# Claremont Business Park 2 Filing No. 1 ). 3

## STREET IMPROVEMENT PLANS (INCLUDING STORM SEWER)

STREET IMPROVEMENT PLANS	
PROJECT NO. 44-037	DATE: 04/28/2020
DESIGNED BY: GW	HORIZONTAL: N/A
DRAWN BY: CLP	VERTICAL: N/A
CHECKED BY: VAS	SHEET 1 OF 12
S101

STORM 10
STA 1+00.00 TO STA 4+07.61
(PRIVATE)

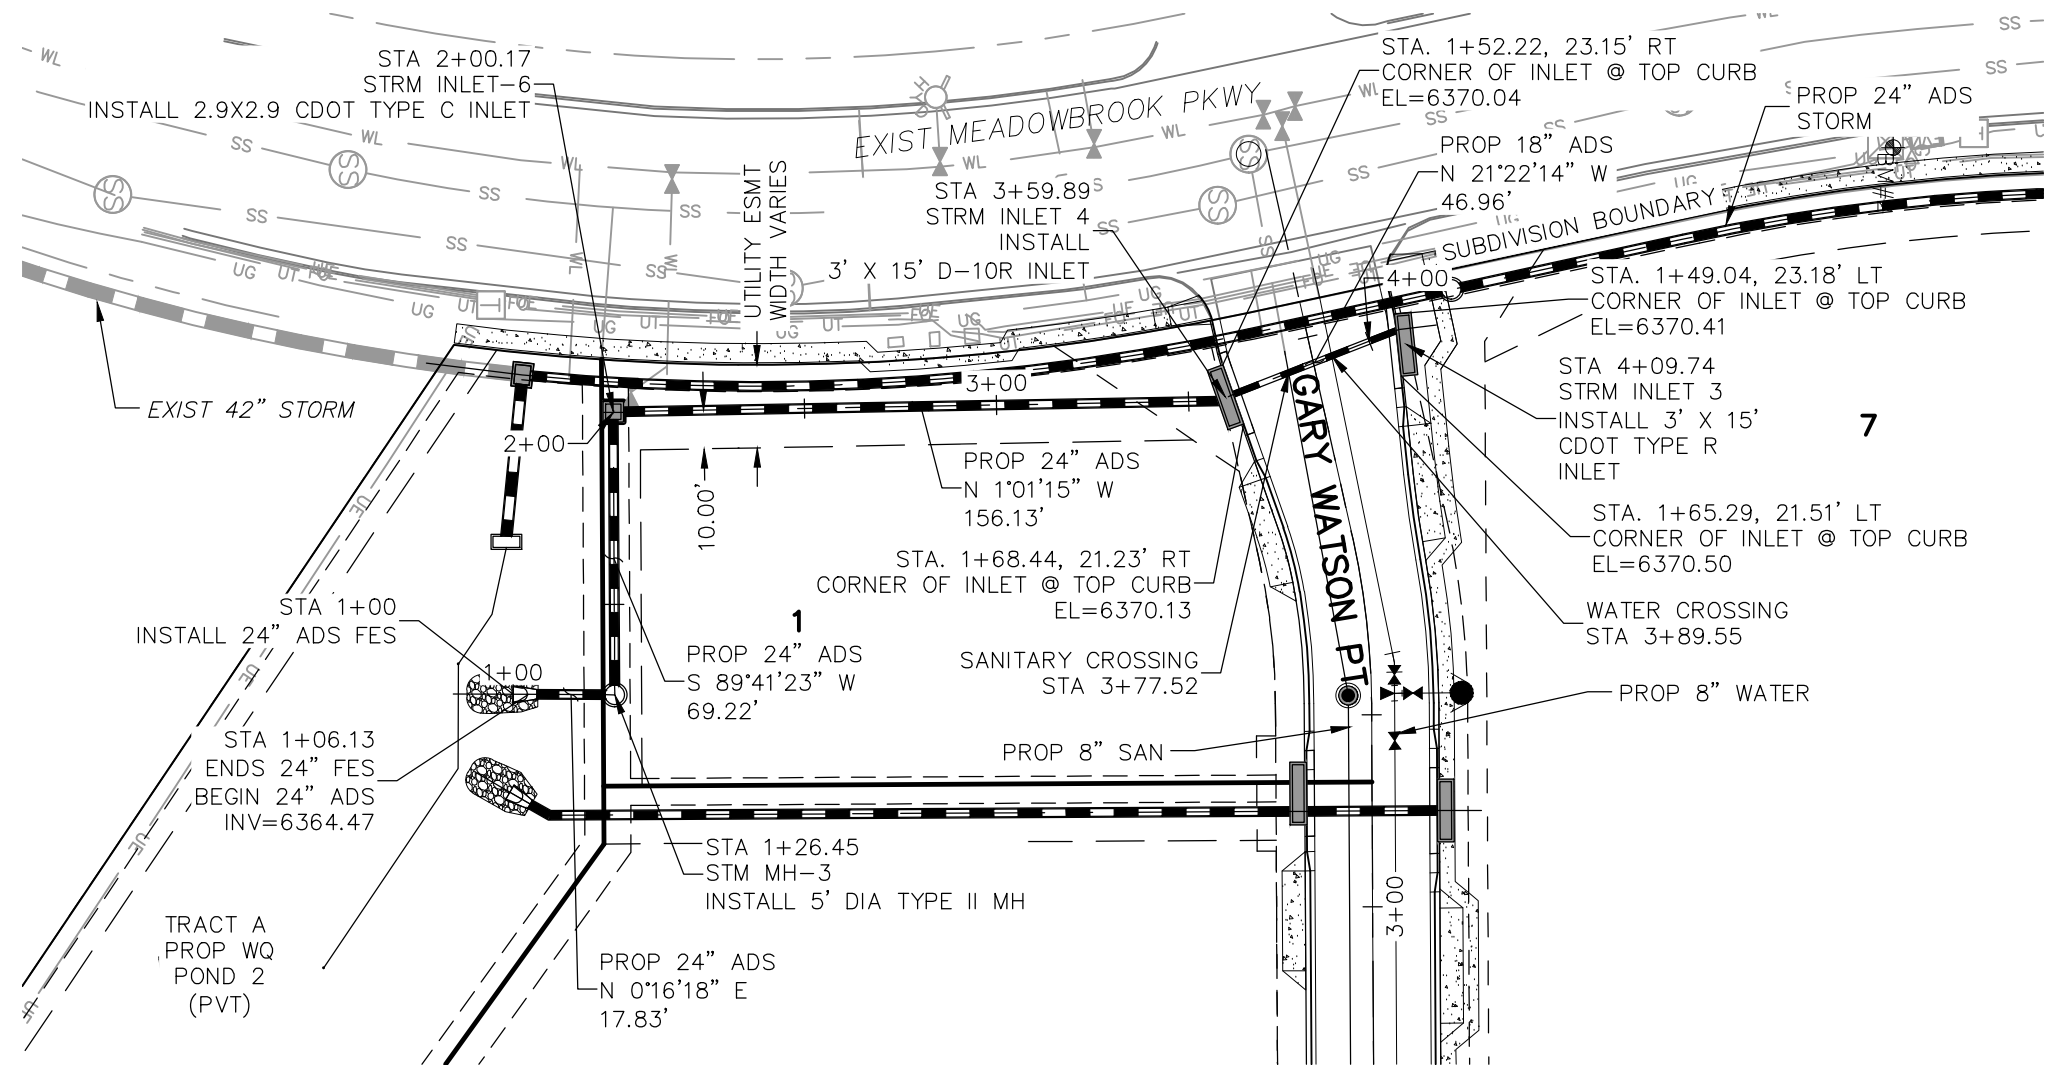
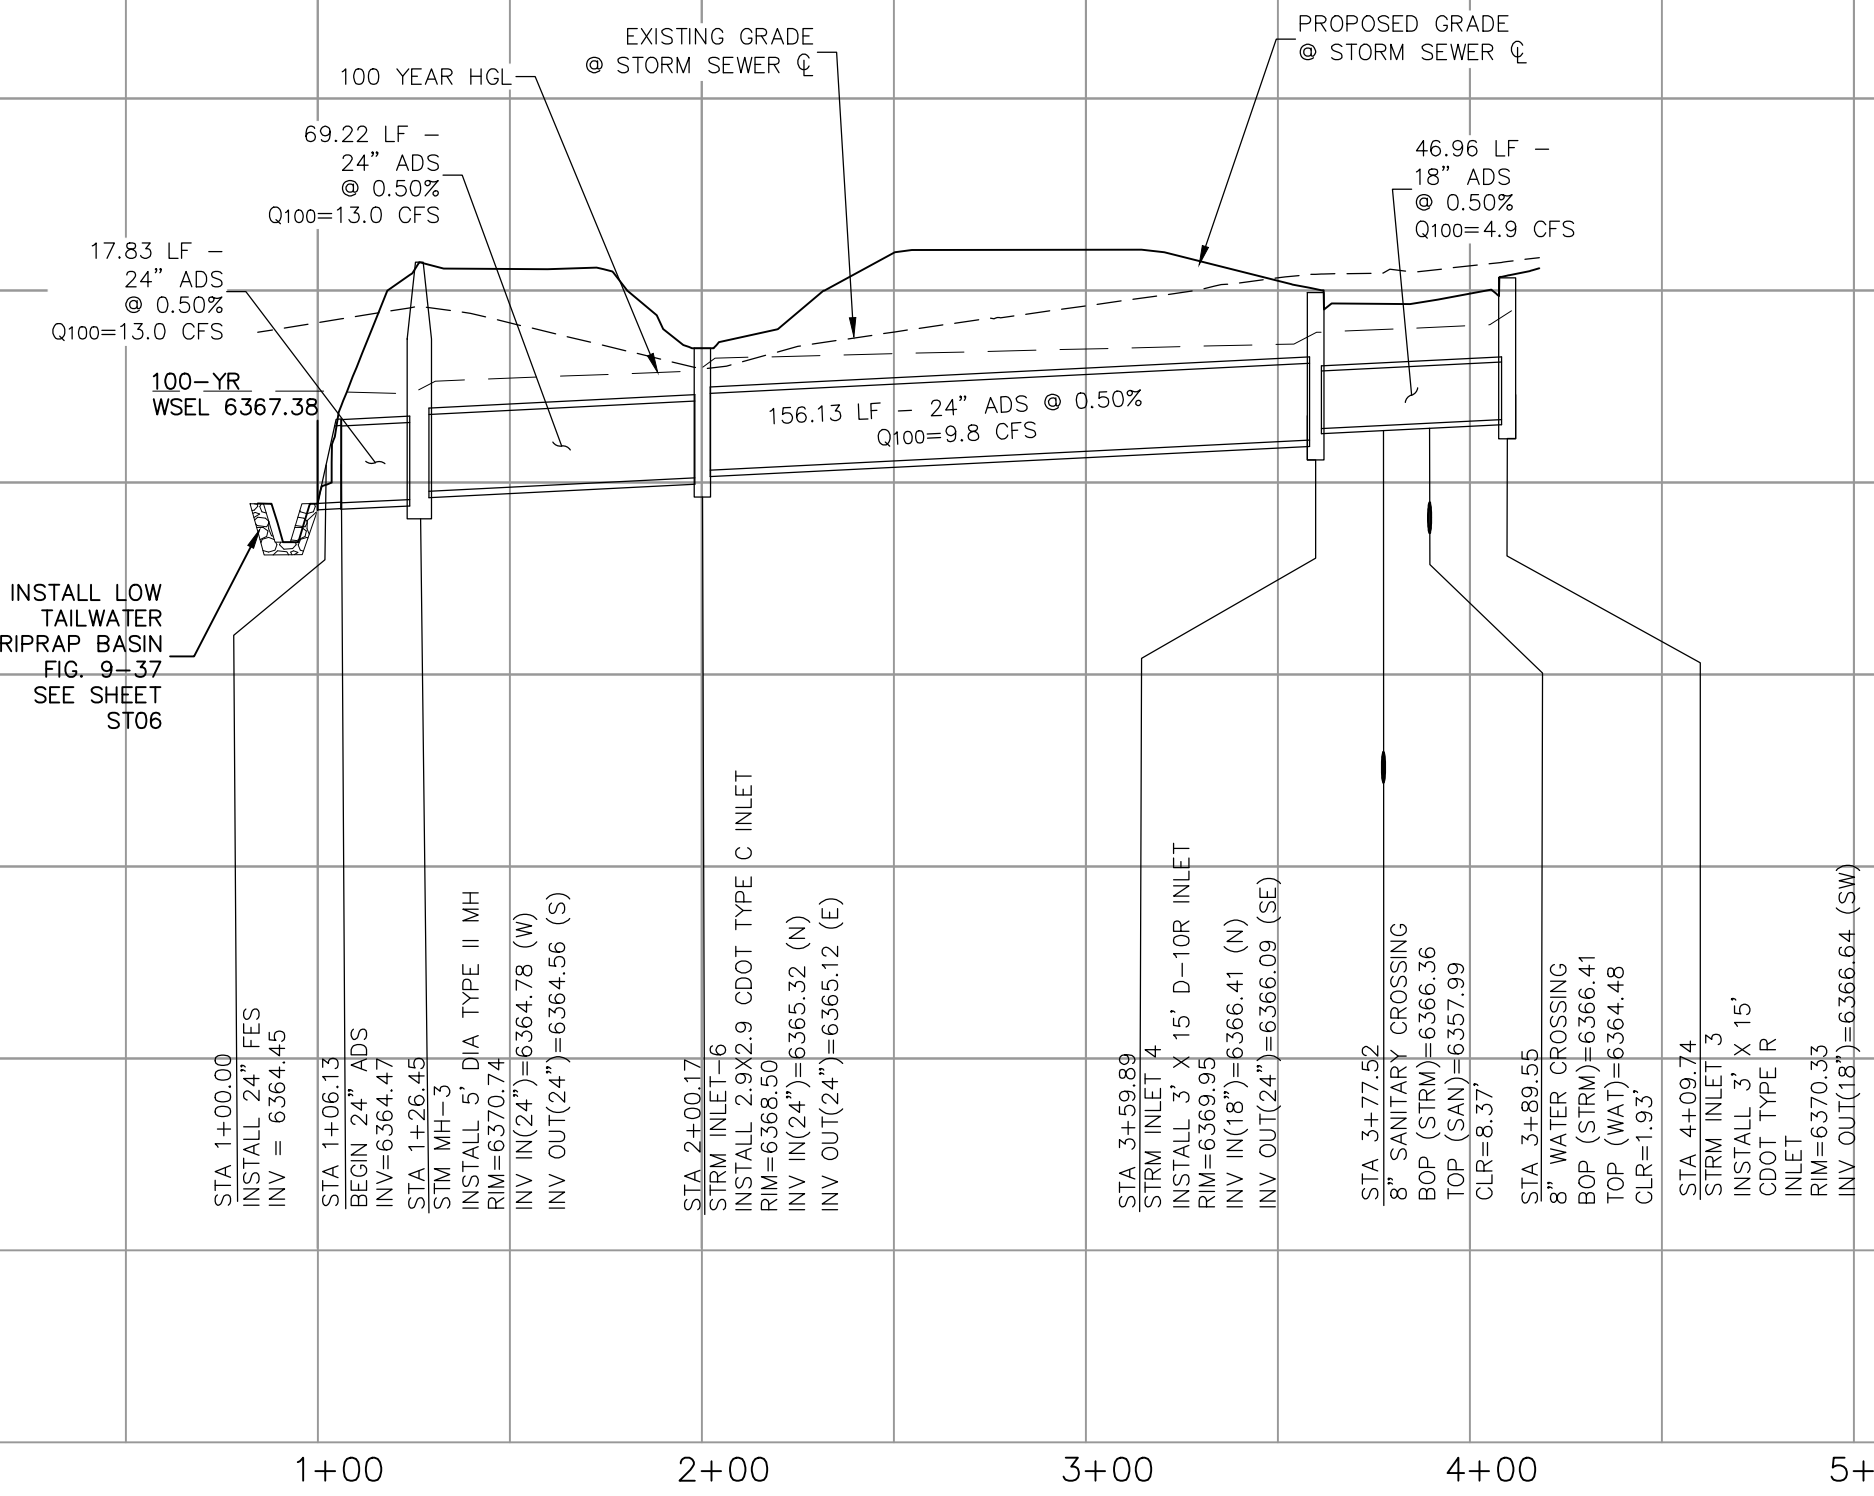
added  
 Please also identify the vertical scale
